Subject: 3/2013/0581 - Proposed demolition of existing garage and porch, proposed new porch and single storey side and rear extension - 11 St Pauls close, Clitheroe Lancashire BB7 2NA

Planning Application Reference: 3/2013/0581

Proposal: Proposed demolition of existing garage and porch, proposed new porch and single storey side and rear extension

Location: 11 St Pauls close, Clitheroe Lancashire BB7 2NA

2 Proposed Ground Floor Plan
1:100 N10080

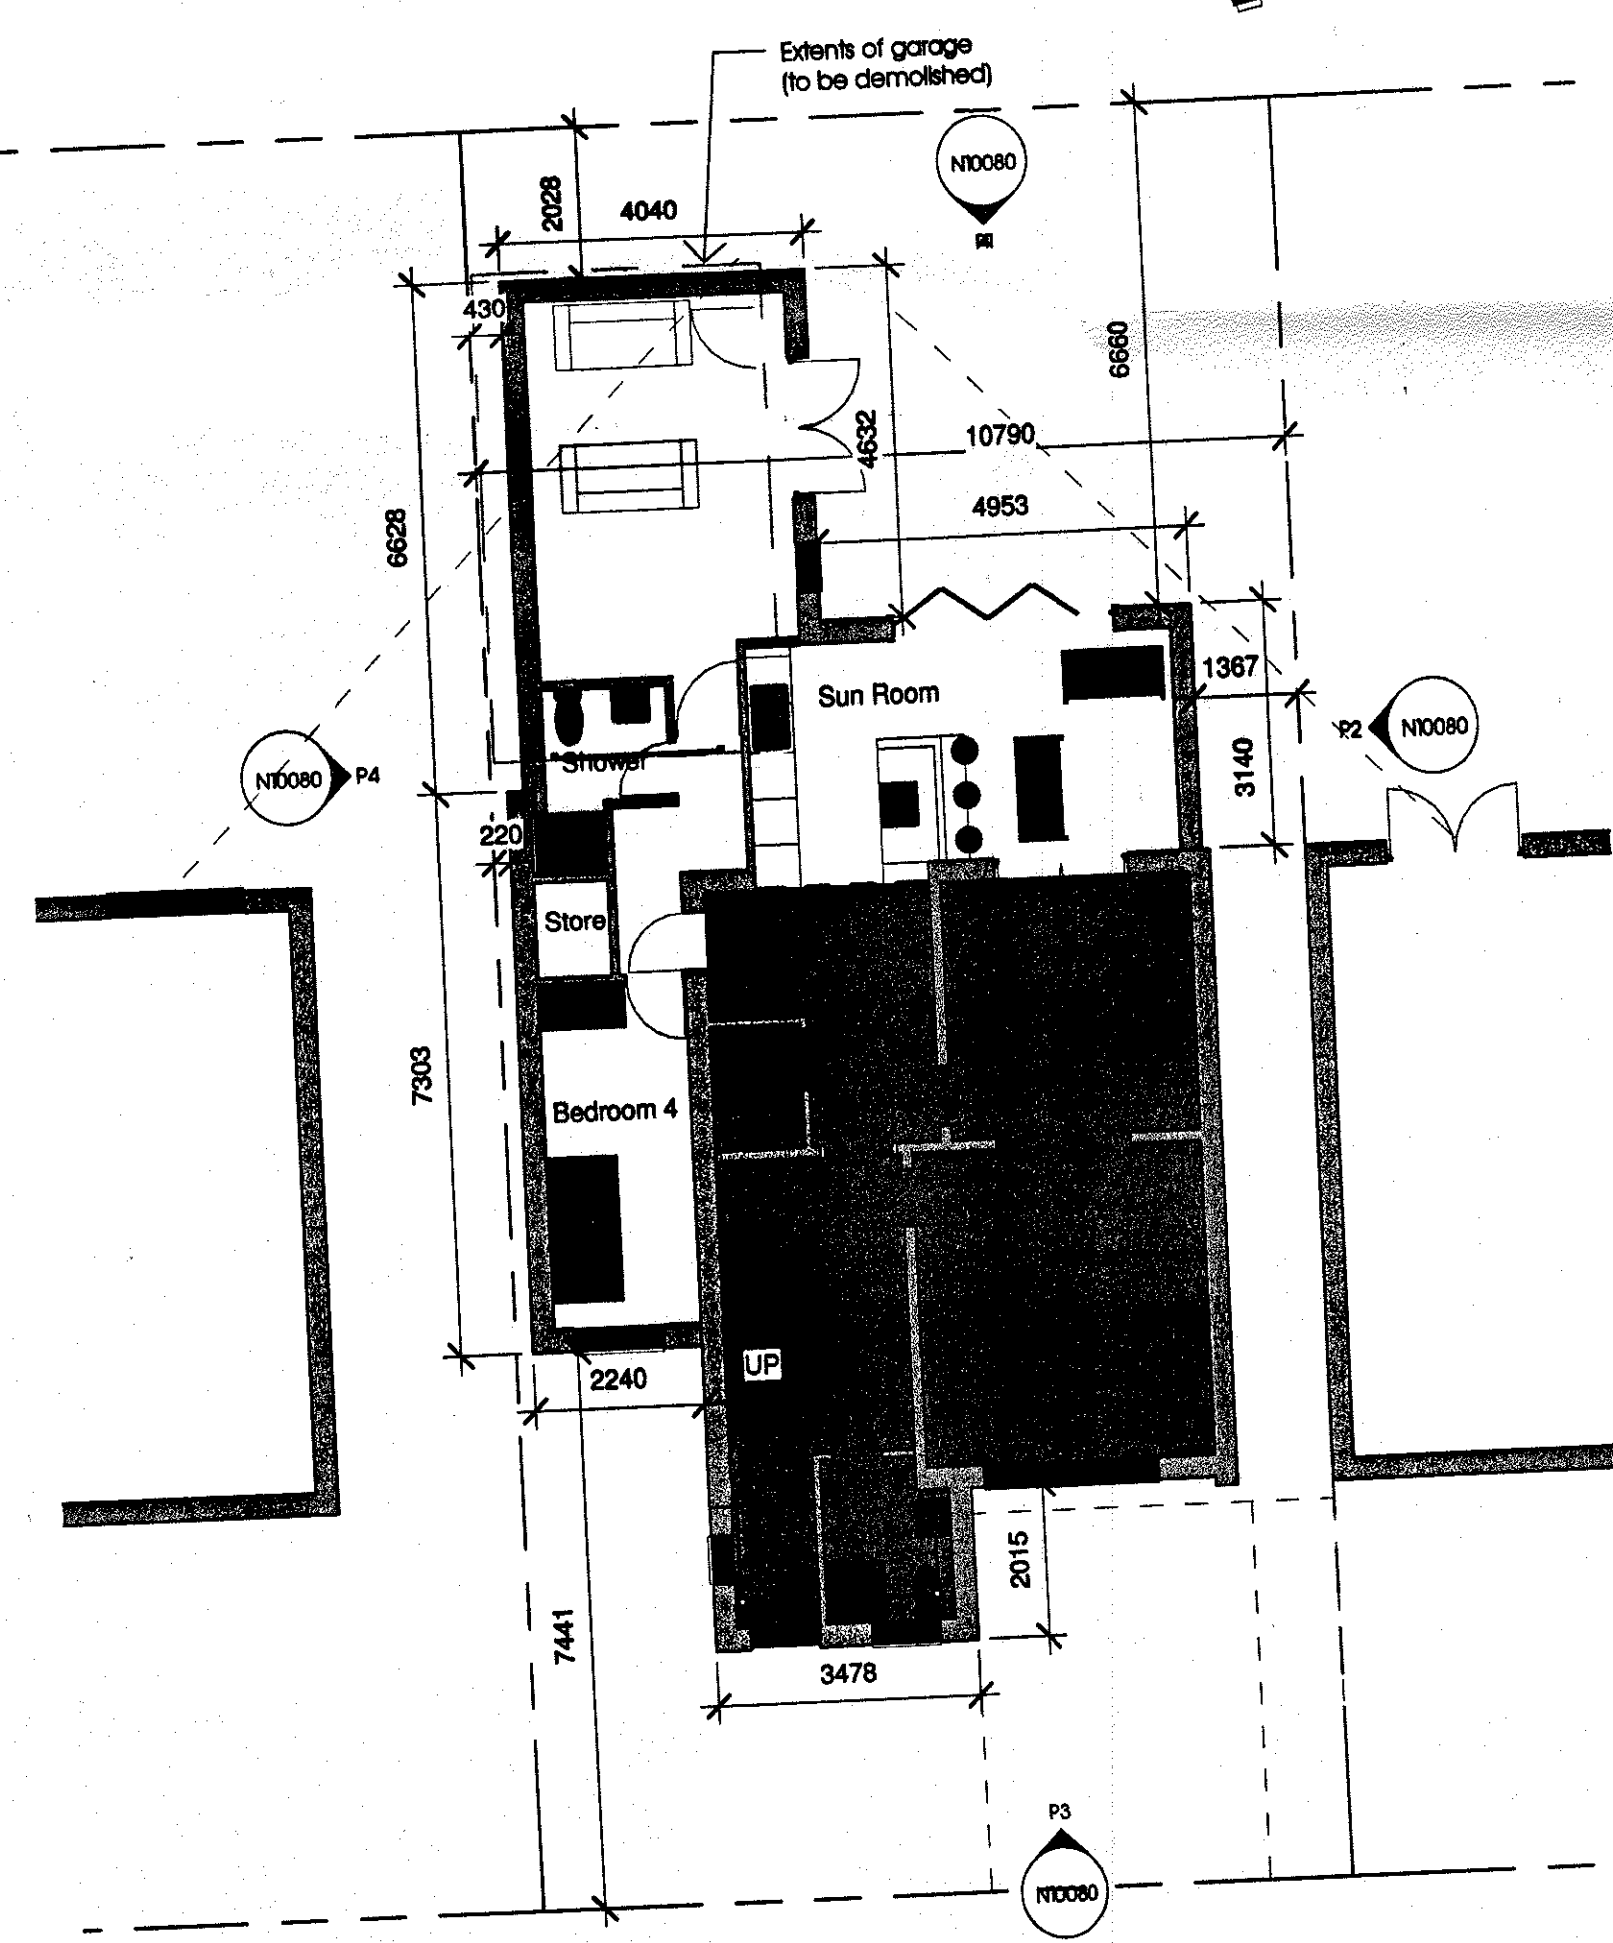
Proposed development is a single storey extension to the side and rear of the existing dwelling. Side extension consists of a new bedroom as well as family sitting area which extends right up to the location of existing garage area. Rear extension consists of sun room. It is recognised that the development will allow better and enhanced life style to the occupants of the dwelling. It is realised that length of existing drive way is reduced due to side extension. With the proposed development there will be 4 bedrooms to use in the dwelling.

According to JLSP residential parking standards, 3 bedroom dwelling will require 2 parking spaces within the cartilage of the property and 4 bedroom dwelling shall require 3 no parking spaces within the cartilage of the property. With the demolition of garage and reduced length of the existing drive way, it is possible to practically accommodate only 1 vehicle on the existing drive way. Parking another vehicle in tandem on existing drive way is likely to overhang on the public foot way which is not acceptable.

With the increased number of bedroom, the parking demand has increased. Thus from the situation of excess availability of existing parking spaces, the proposed development suggests lack of parking within the cartilage of the property. This situation is likely to affect the public highway. In view of the above considerations there is an objection to the proposed development in its current form and recommend refusal on highway grounds.

If applicant is willing to amend the layout to address the highways concerns, I am happy to review the application accordingly.
